**Your Ref: 2023/93350**  
**Our Ref: Z005868**

**12th December 2023**

**Former Deighton Centre, Deighton Road, Deighton, Huddersfield - Development of former Deighton Centre (previously Deighton High School) comprising Social Emotional and Mental Health School (use class F1) comprising single and two storey educational buildings; roof mounted photo-voltaic panels; sensory garden spaces; multi-use games areas; landscaping; hardstanding areas; carparking; access with secure fencing and ancillary development**

### **Appendix 3: Indicative Drainage Strategy**

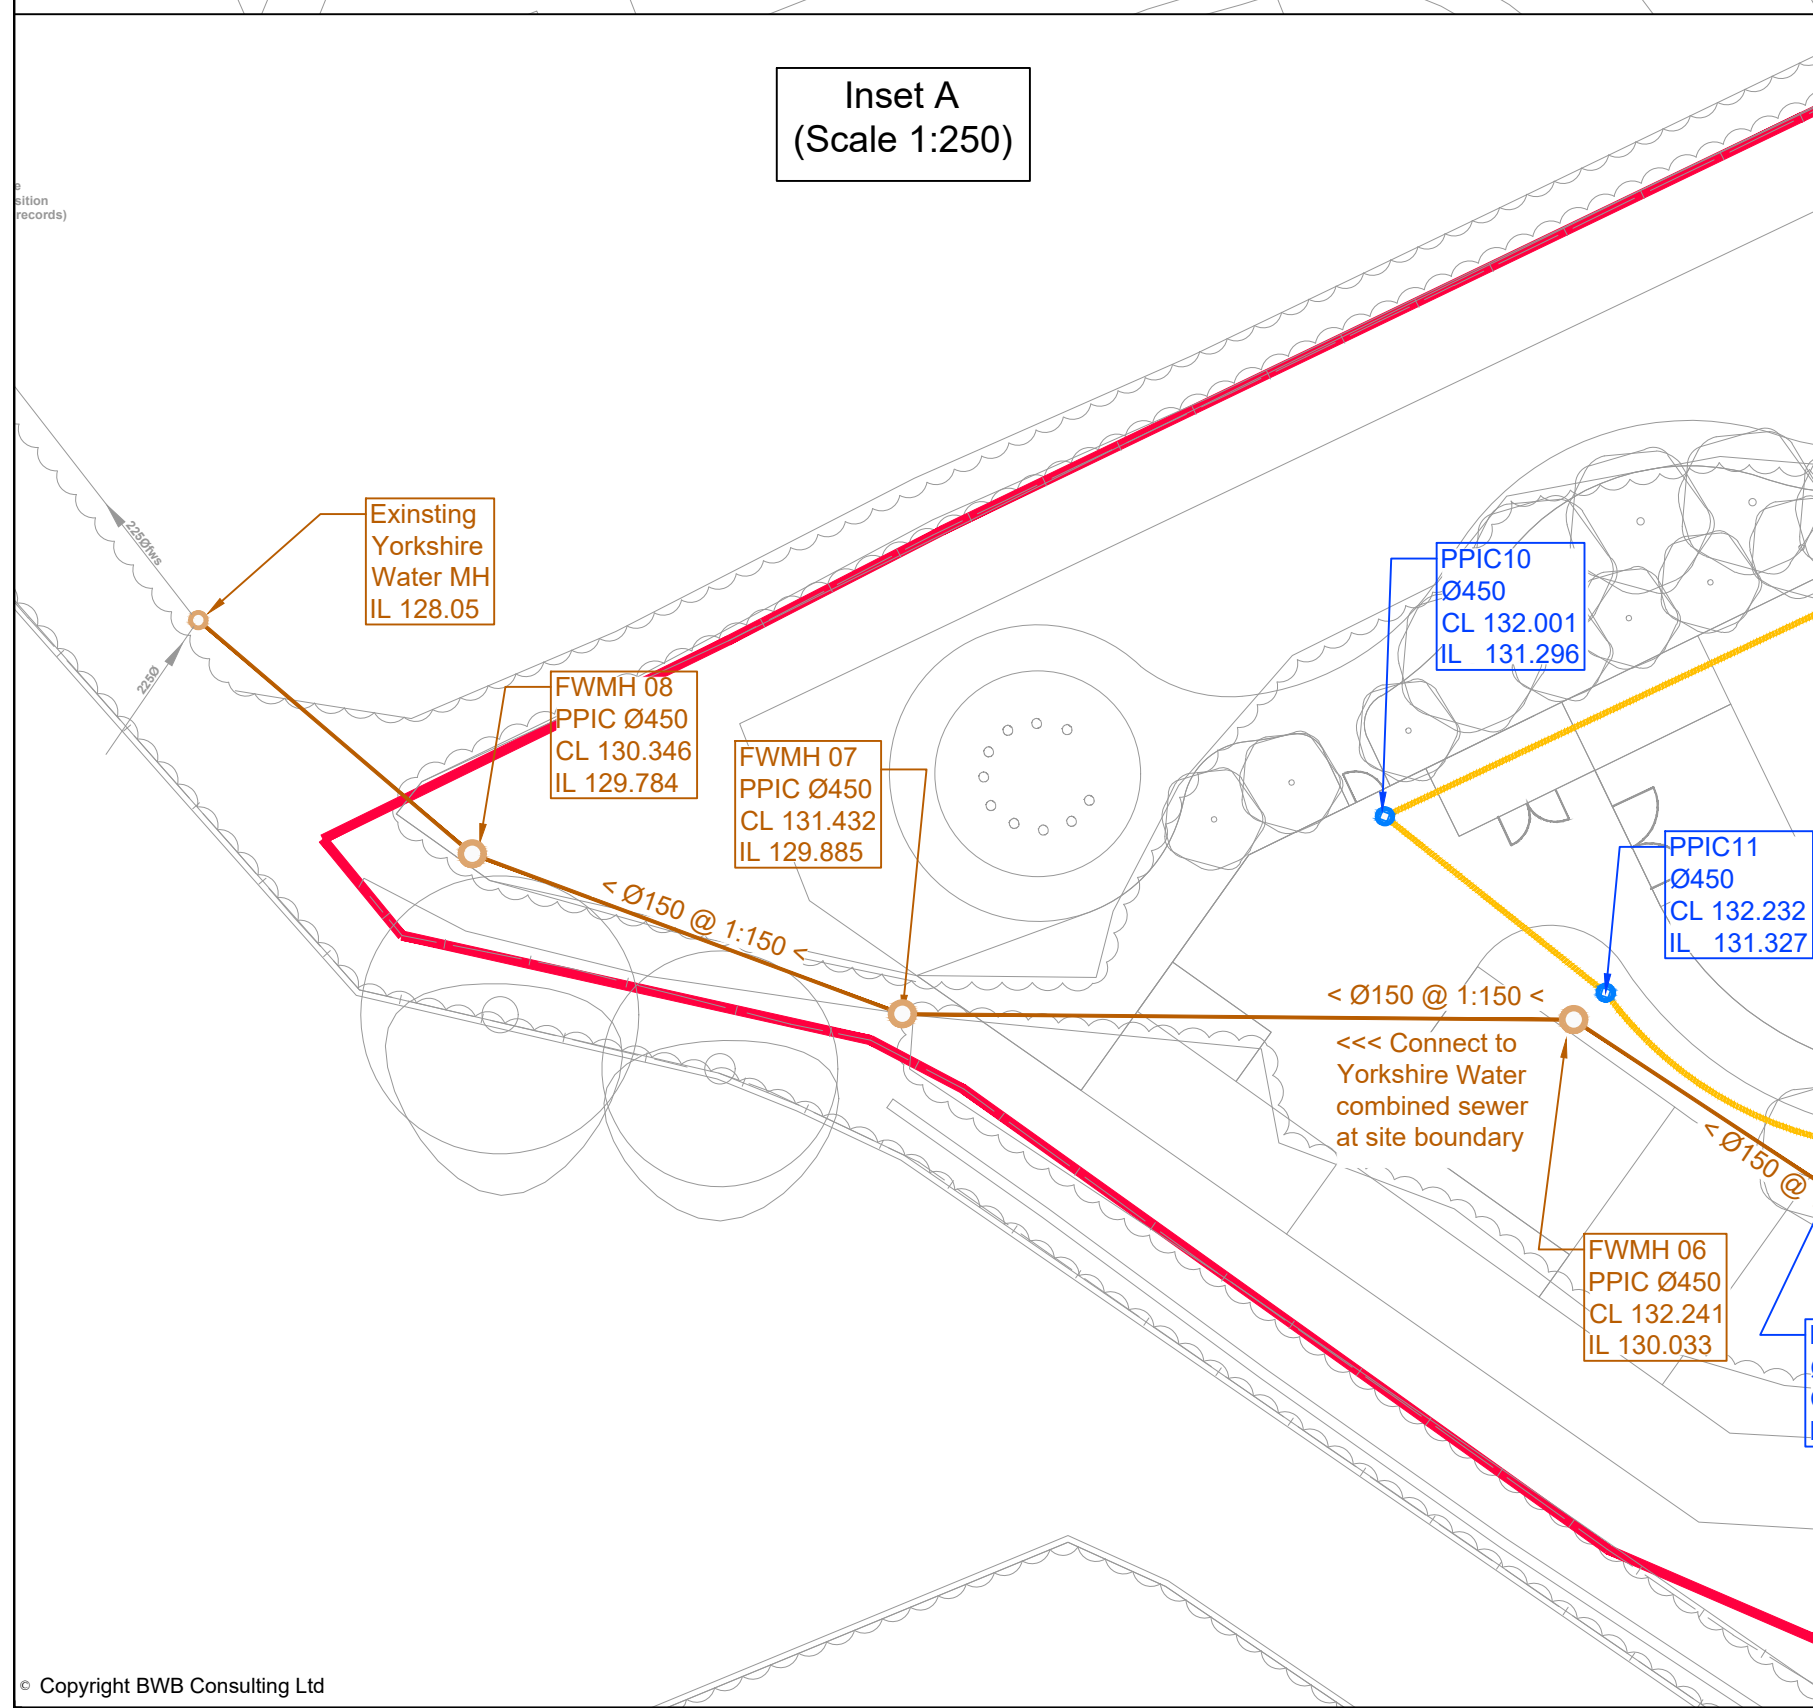
1.) Yorkshire Water has no objection in principle to the drainage details submitted on drawing 'Proposed Drainage' 22308-BWB-XX-XX-DR-C-0500 (revision P04) dated 26/09/23 that has been prepared by BWB, namely: -

- a.) The proposed separate systems of drainage on site and off site with combined off-site
- b.) The proposed amount of domestic foul water to be discharged to the public combined water sewer
- c.) The proposed amount of curtilage surface water to be discharged via infiltration
- d.) The proposed point(s) of discharge of foul and surface water to the respective public sewer and infiltration tank.

**The development shall be carried out in accordance with the details shown on the submitted plan, "Proposed Drainage' 22308-BWB-XX-XX-DR-C-0500 (revision P04) dated 26/09/23 that has been prepared by BWB", unless otherwise agreed in writing with the Local Planning Authority.**
